Your Ref: OWPC21814
Our Ref: EP/22/19/PL 14-02-2019
Please ask for:
Stuart Corbey

New external walkaway with stair & ballstrade
78 Orchard Road East Preston

Thank you for your internet representation made on 20th March 2019 which has been recorded as '**an objection**' with the comments as follows:

front (Orchard Road) proposed elevation (A1 1:100 A3 1:200)

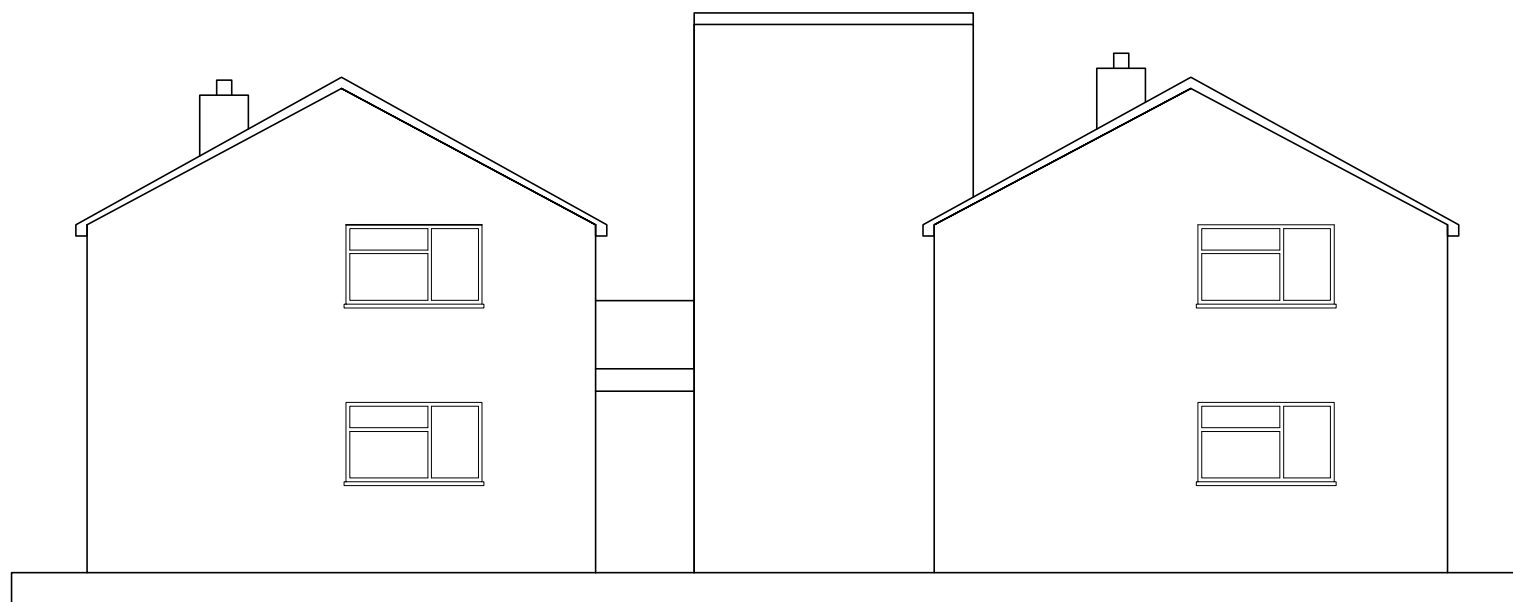
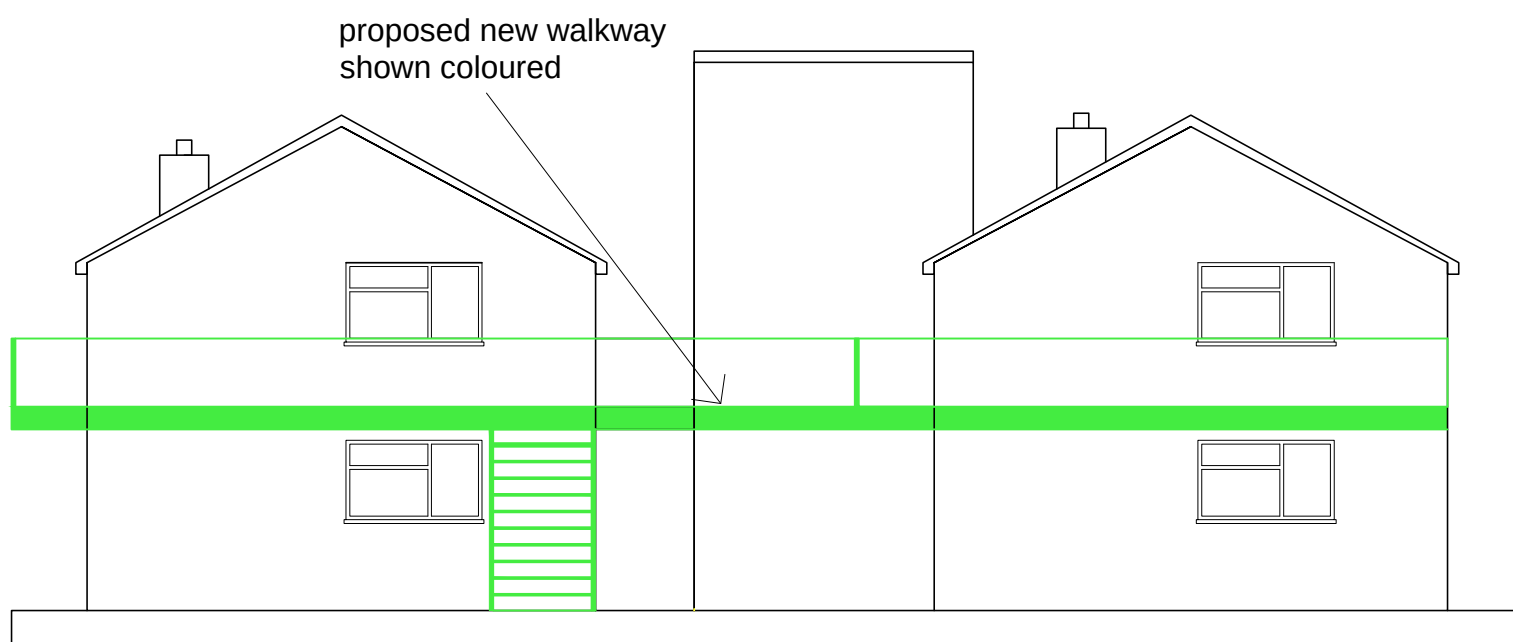
The proposed walkway along the front of the houses owned by Arun District Council would have a severely adverse effect on the appearance of these buildings. No explanation is provided for its construction, nor for the decision to place it at the front rather than the rear of these buildings. We do not therefore know whether there are any benefits to offset the aesthetic harm that the walkway would cause.
